Please ask for: Mrs D Johnson
Email: daun.johnson@arun.gov.uk
Telephone: 01903 737762
Our Ref: CM/32/20/PL
Your Ref:
Date: 30th September 2020

Application for Planning Permission

Development: Change of use of land (B Storage) & erection of 1 No. detached single storey, two bedroom dwelling. This application affects the setting of a listed building & is a Departure from the Development Plan. This application is in CIL Zone 3 & is CIL Liable as new dwelling.

Location: Land Adjacent To Church Farm Barn Hosemere Green Lane BN17 5QZ

Figure 1: Proposed block plan

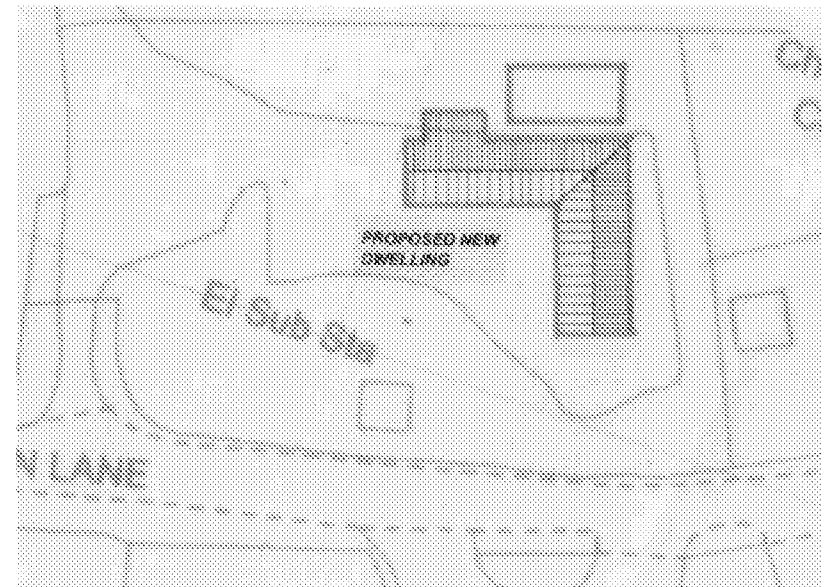
Block Plan

Please provide measurements from the proposal to the site boundaries.
